TOWN & COUNTRY PLANNING (ENVIRONMENTAL IMPACT ASSESMENT)(ENGLAND & WALES) REGULATIONS 1999

REGULATION 19 - SCHEDULE OF FURTHER INFORMATION REQUIRED

BROADWATER ROAD WEST ENVIRONMENTAL STATEMENT, SEPTEMBER 2010

Response to Schedule

BROADWATER ROAD WEST, WELWYN GARDEN CITY
DETAILED PROPOSALS: SHREDDED WHEAT FACTORY
FOOD STORE BAY STUDIES
568_07_163
SCALE: 1:50 @ A0; 1:100 @ A2

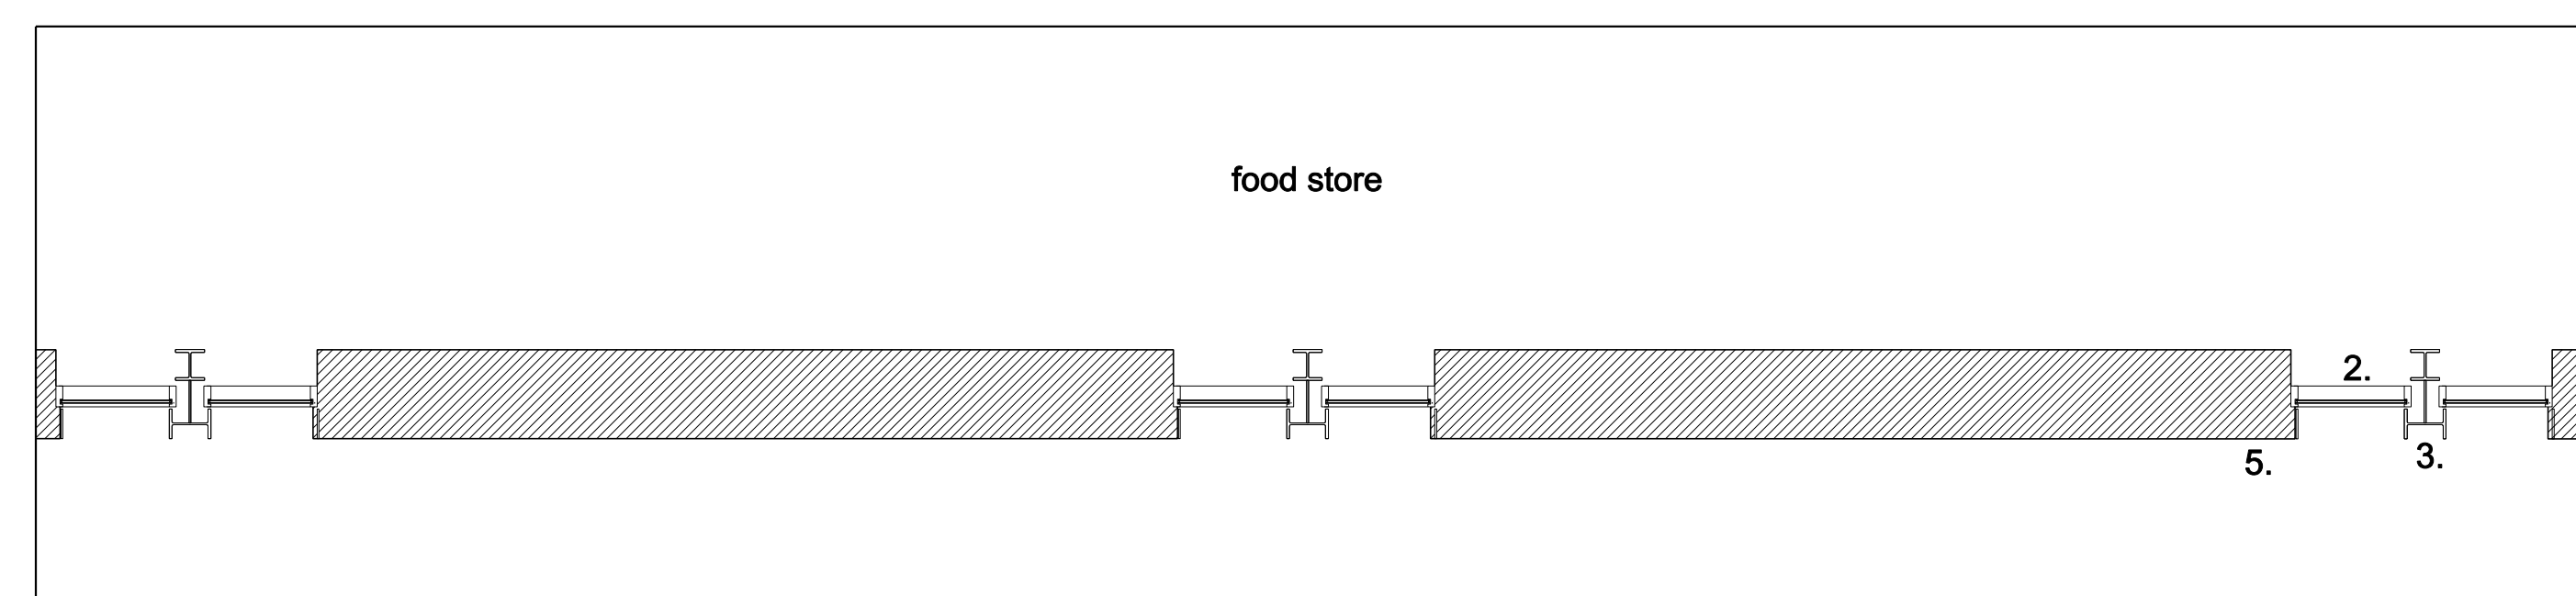
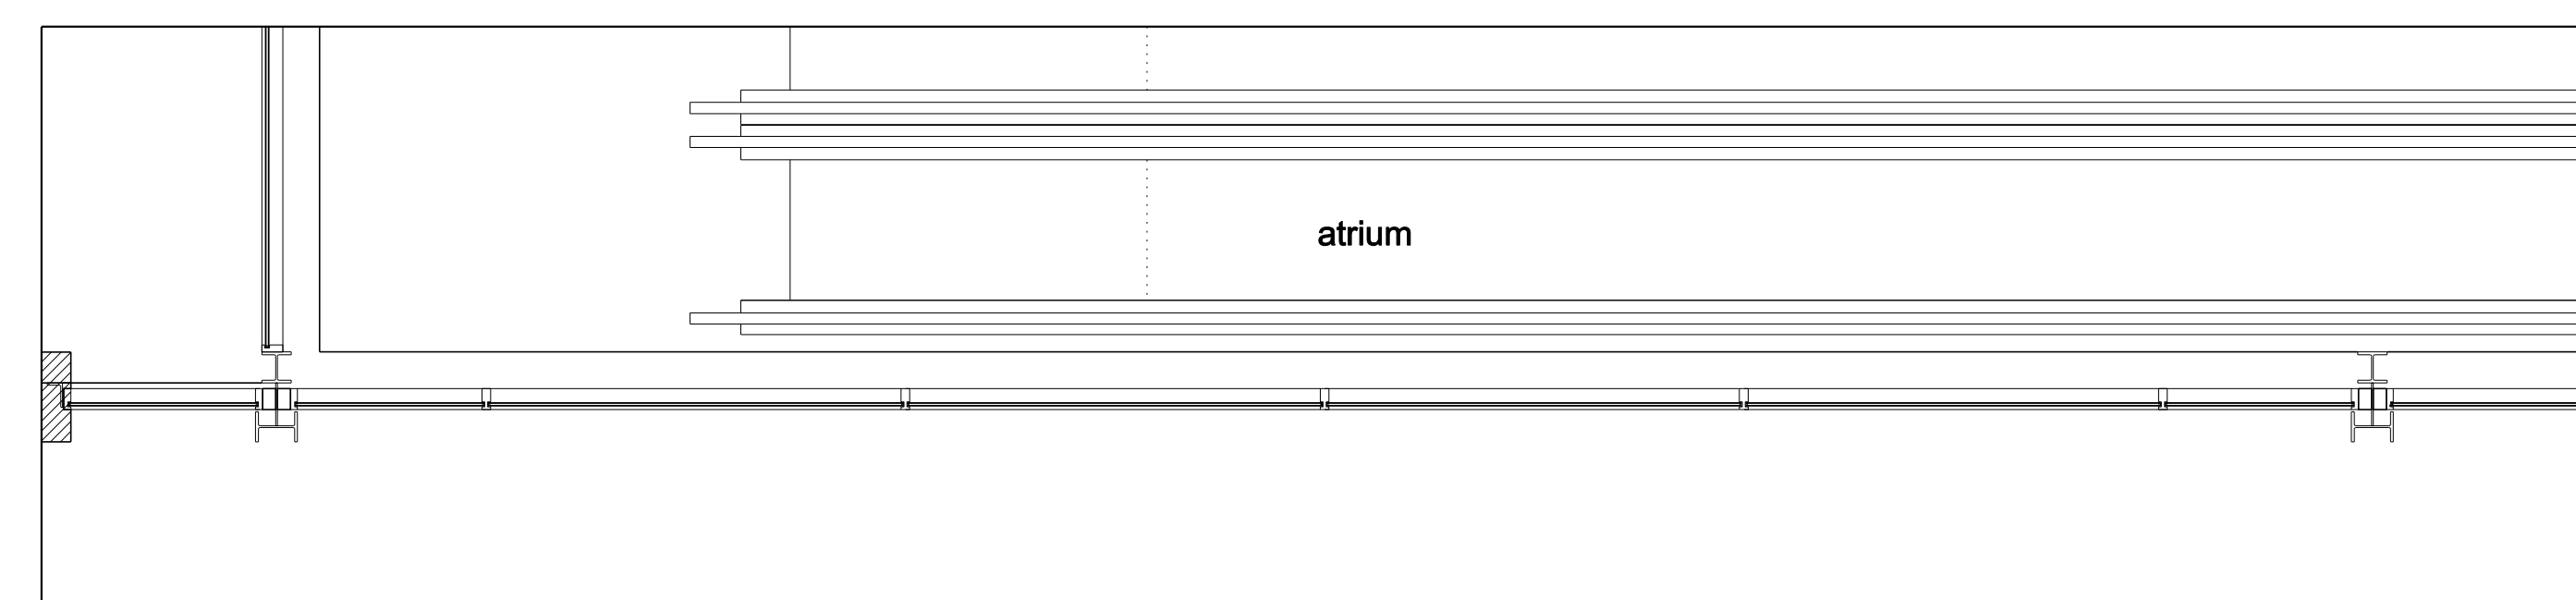
- 2.2 The scheme drawings appear to show a CHP within the Tesco store. Clarification should be provided of the CHP proposals for the development.

This was an oversight in the planning drawing the CHP unit will be removed. Confirmation is given that the Retail Store will be fed from the energy centre.

BROADWATER ROAD WEST, WELWYN GARDEN CITY
 DETAILED PROPOSALS: ENERGY CENTRE
 PROPOSED GENERAL ARRANGEMENTS
 568_07_165
 SCALE: 1:100 @A0 1:200 @A2

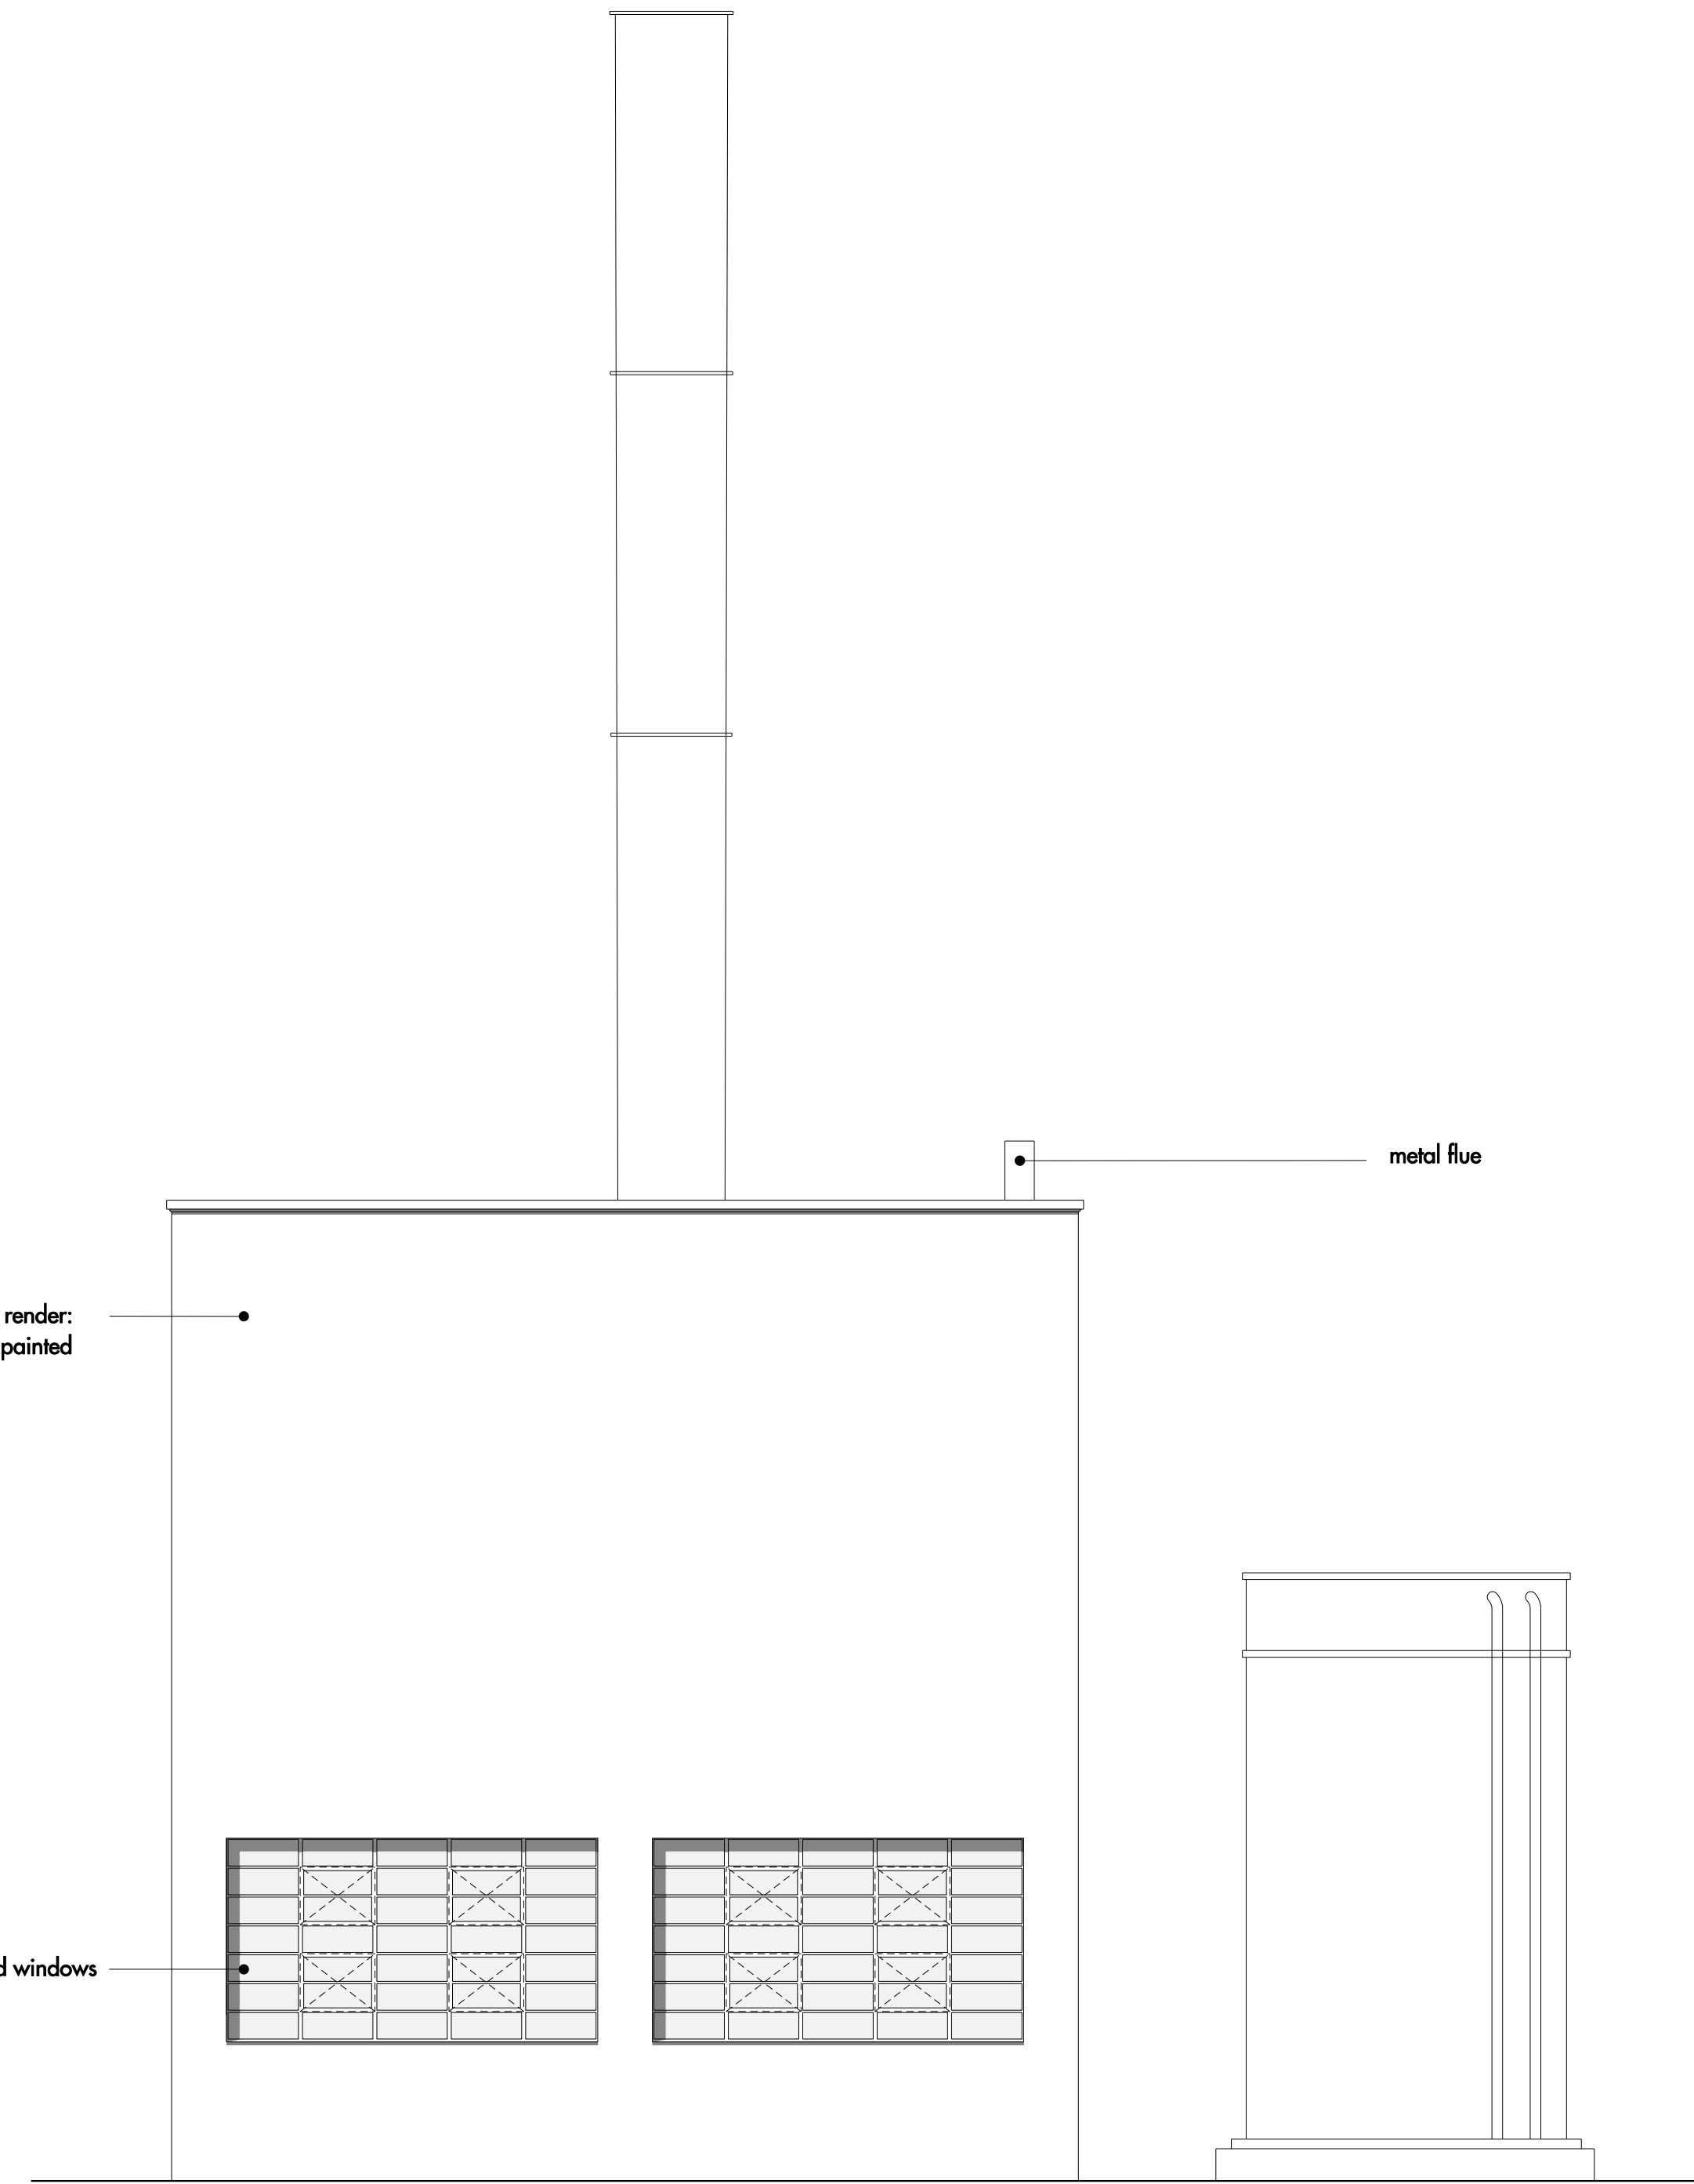
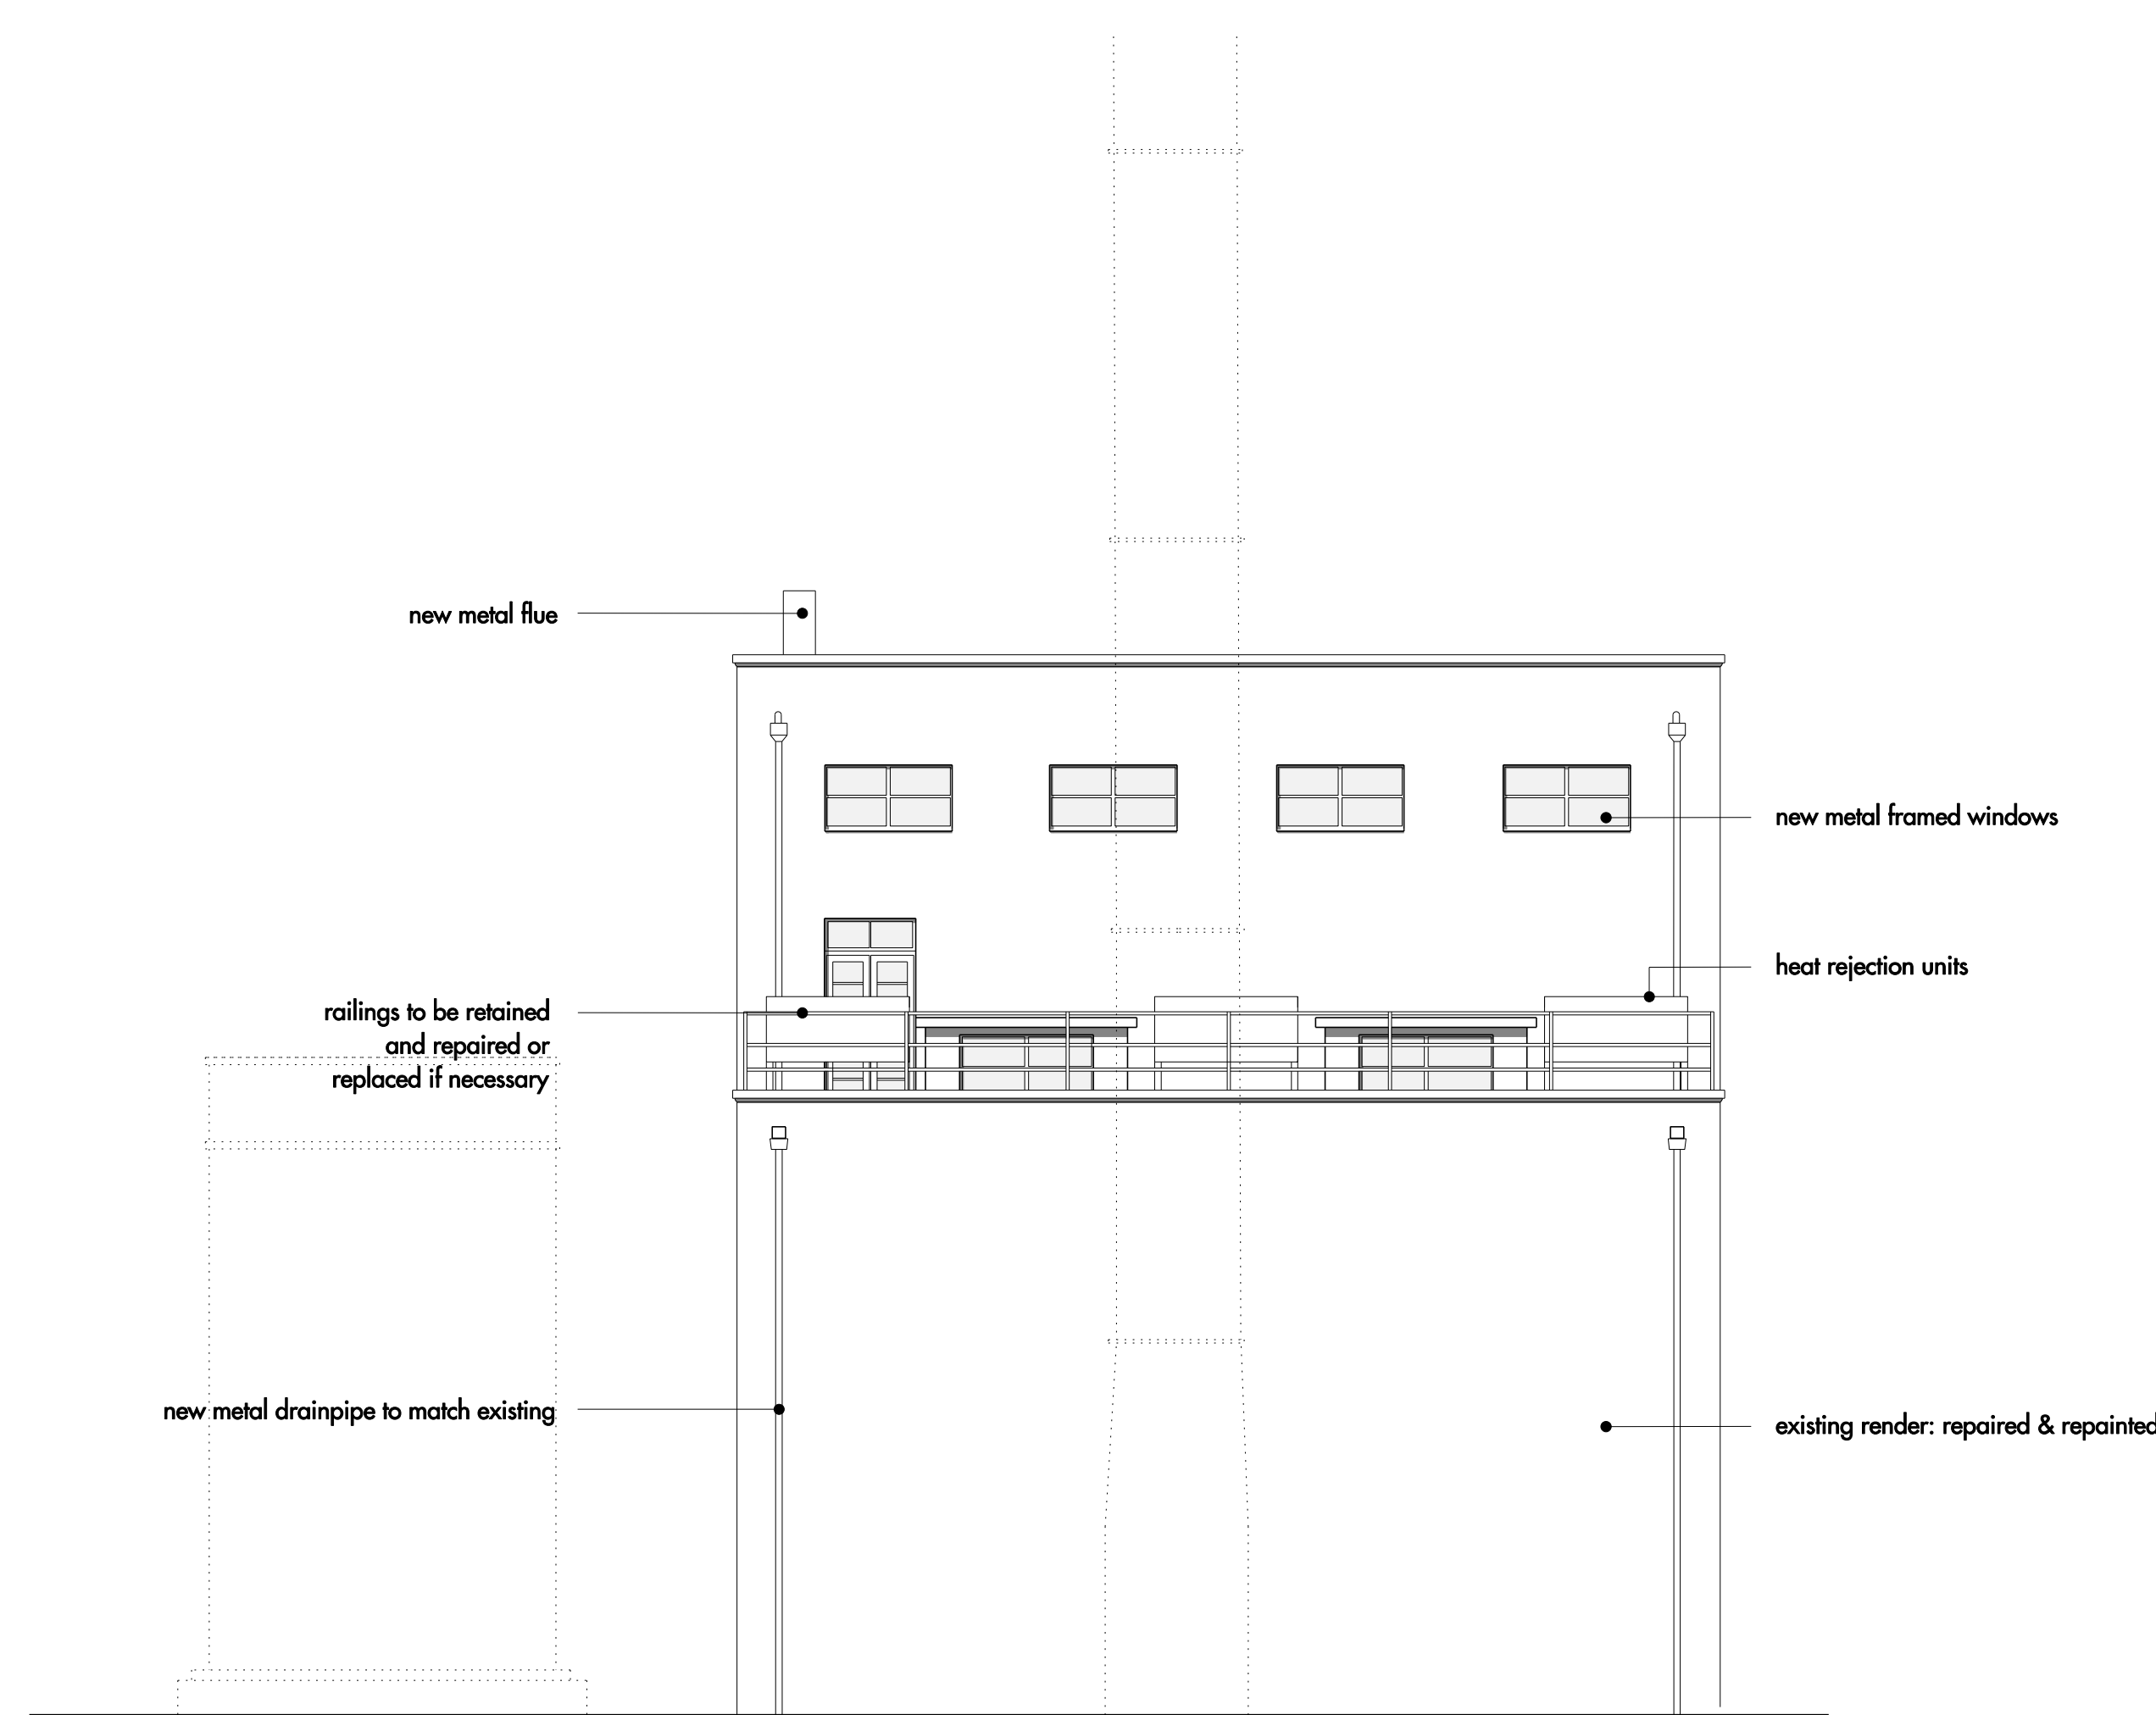
- 2.1 Confirmation is needed on the fuel type proposed for the CHP, and whether or not the CHP will serve the whole development. Confirmation is also needed as to whether the existing building and stack proposed to be re-used for this purpose will be adequate to house all of the plant required. Confirmation should be provided of the air quality, noise and visual impacts that will result from the CHP, as nearby residential units and other uses which may be adversely affected by the CHP lie within the area of the detailed application.

The energy strategy and statement (Part C Appendix C) has been updated in conjunction with the scheme description to make it clear that the existing boiler house is to be used to house the energy centre for both detailed and outline application

areas, and that the existing stack will be re-used, to incorporate new internal gas flues for the gas-fired CHP plant. The energy centre is fully considered the environmental topic impact assessments
